Gatwick Airport Northern Runway Project

The Applicant's Response to the Examining Authority's
Written Questions – Landscape, Townscape and Visual
Resources – Appendix A – Response to LV.1.1

Application Document Ref: 10.16

<p>ORIENTATION</p>	DRAWING NO.	REVISION
	<b>FIGURE 5.2.1f</b>	<b>For ES Issue</b>
	DRAWN BY	PM / CHECKED BY
	<b>MS</b>	<b>KC</b>

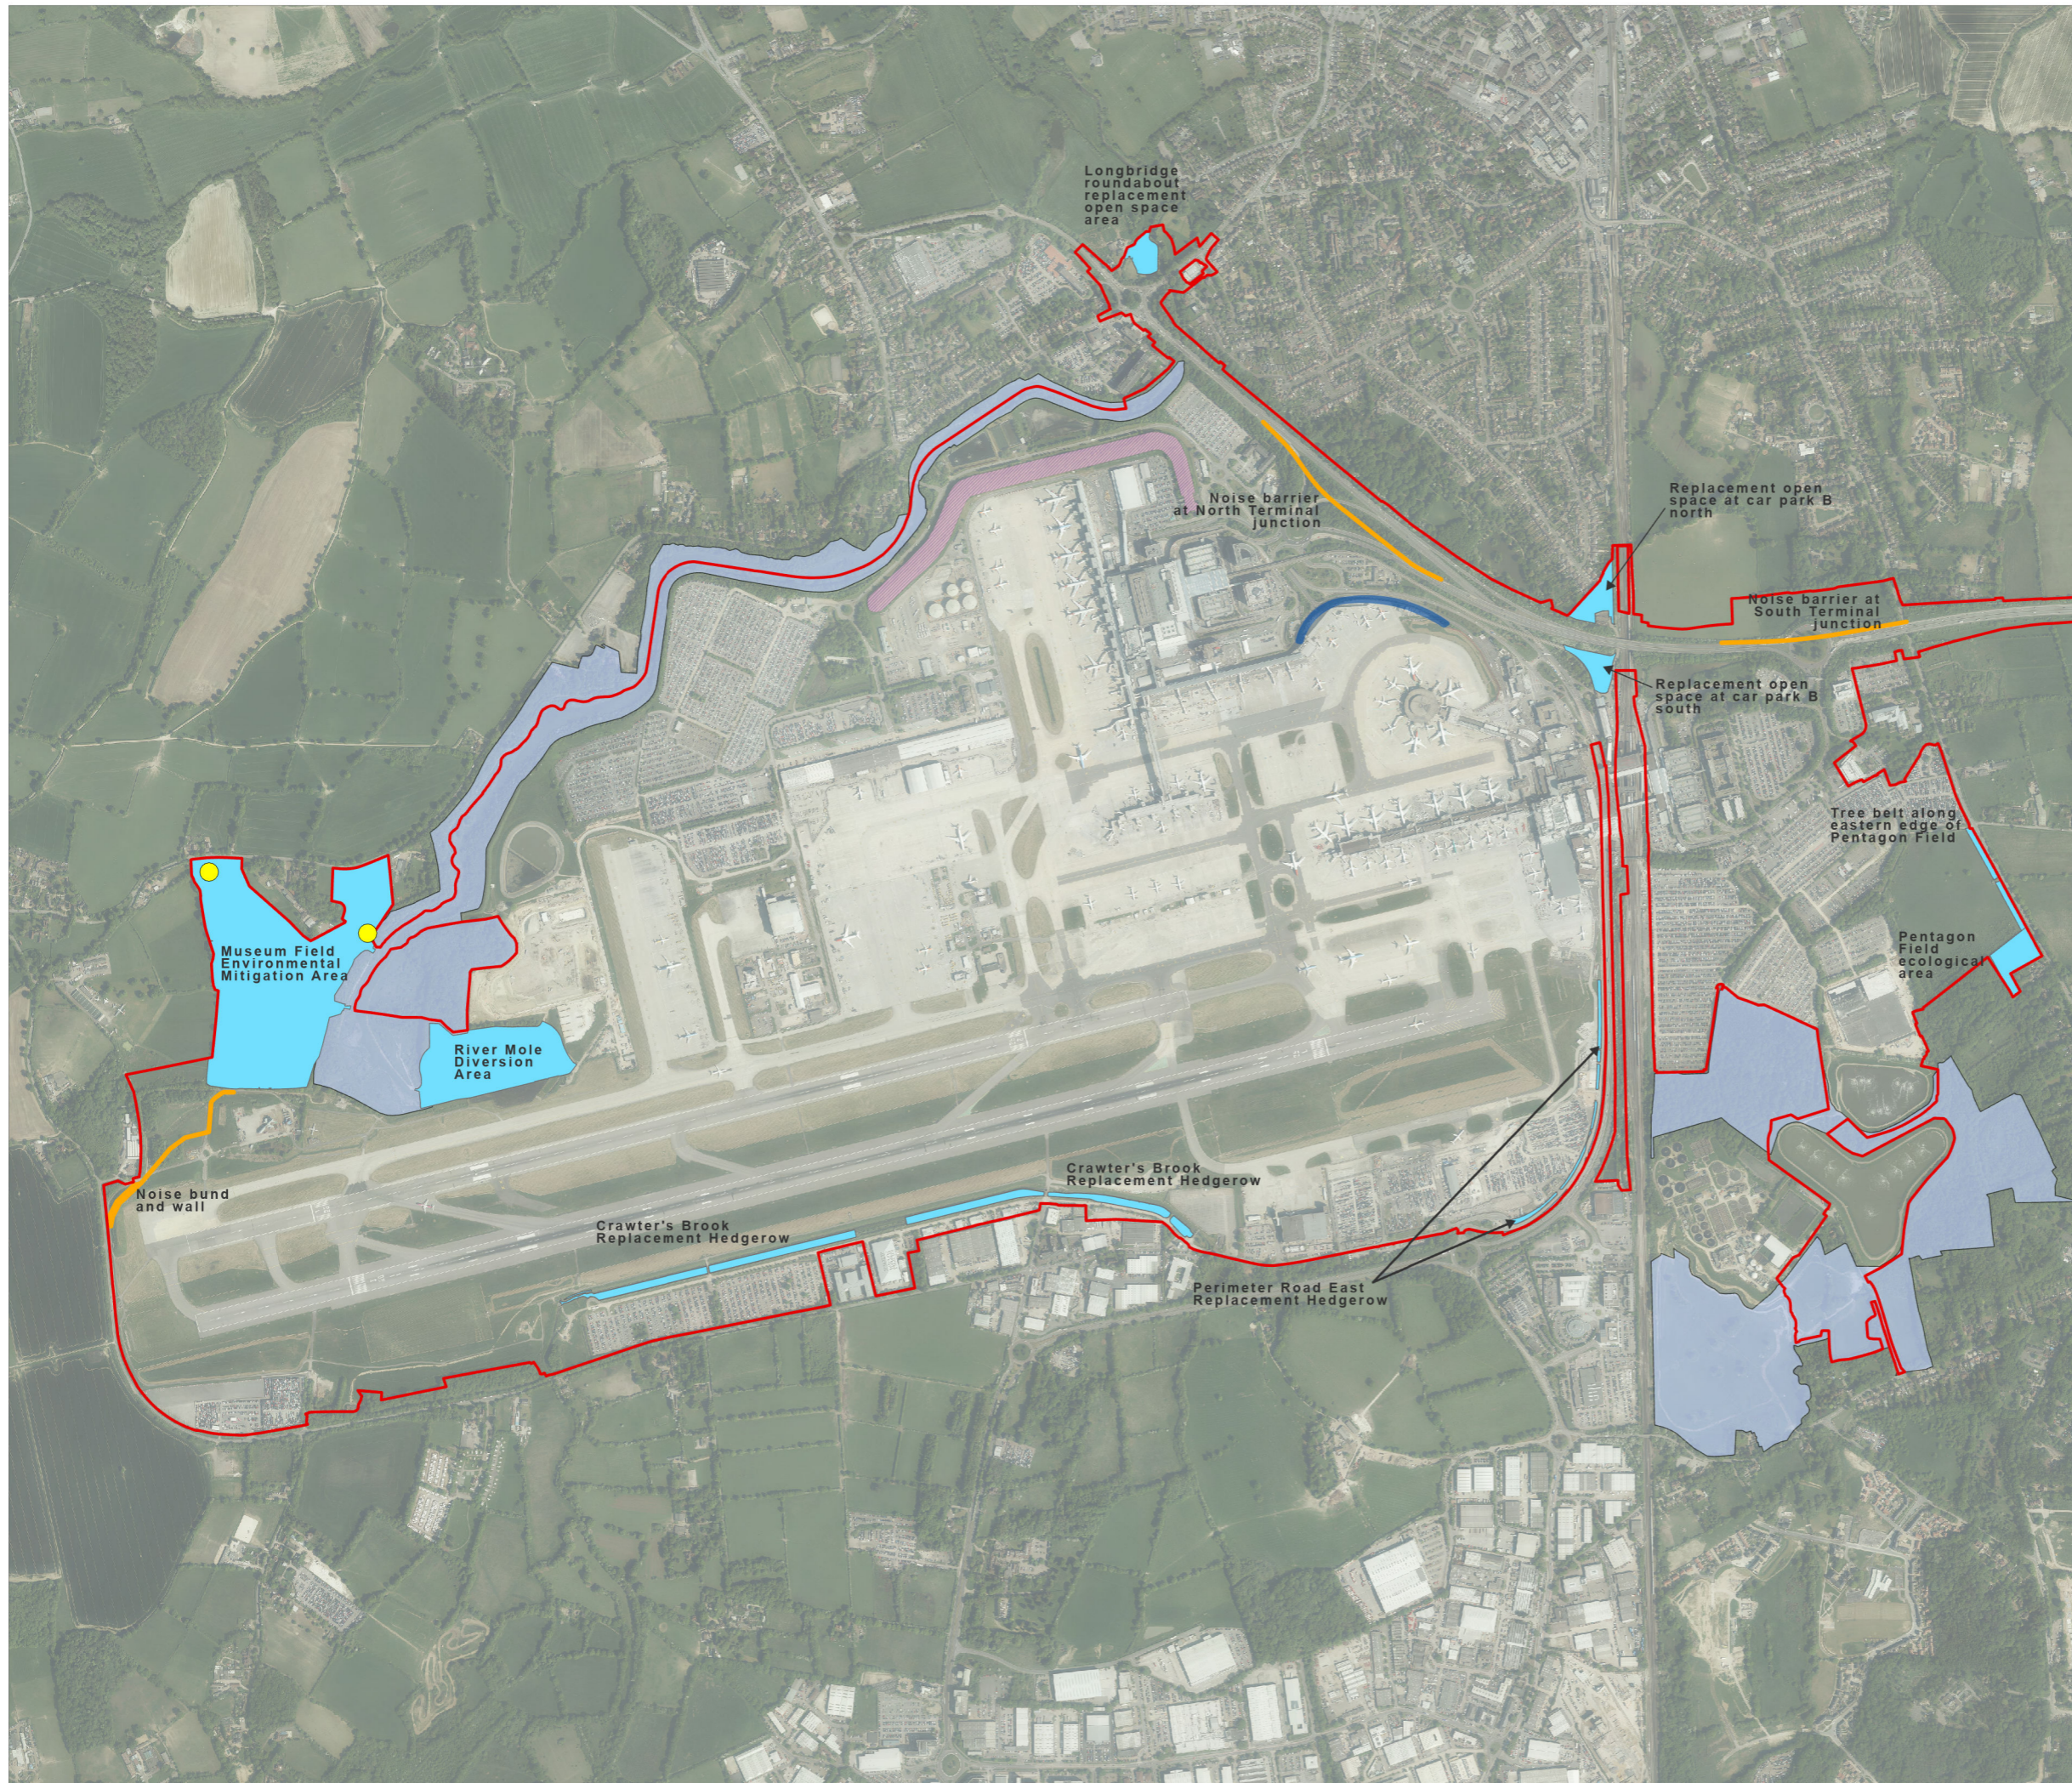
Provide further details on proposed construction/ contractor compounds, to include likely lighting details, height and colour of site cabins (dual or single stacked), stockpile heights, and areas where the compounds may be visible from.

1.2 The construction of the Project will be facilitated by temporary construction compounds and storage areas, located across the Project site. Further information on how GAL intends to use these temporary construction compounds to construct the Project can be found in **ES Appendix 5.3.1: Buildability Reports (Parts A and B)** [[APP-080](#), [APP-081](#) and [REP2-013](#)], **ES Chapter 5: Project Description** [[REP1-016](#)] and **ES Appendix 5.3.2: Code of Construction Practice (CoCP)** [[REP1-021](#)]. The location of these compounds is shown on **ES Figure 5.2.1f** [[AS-135](#)].
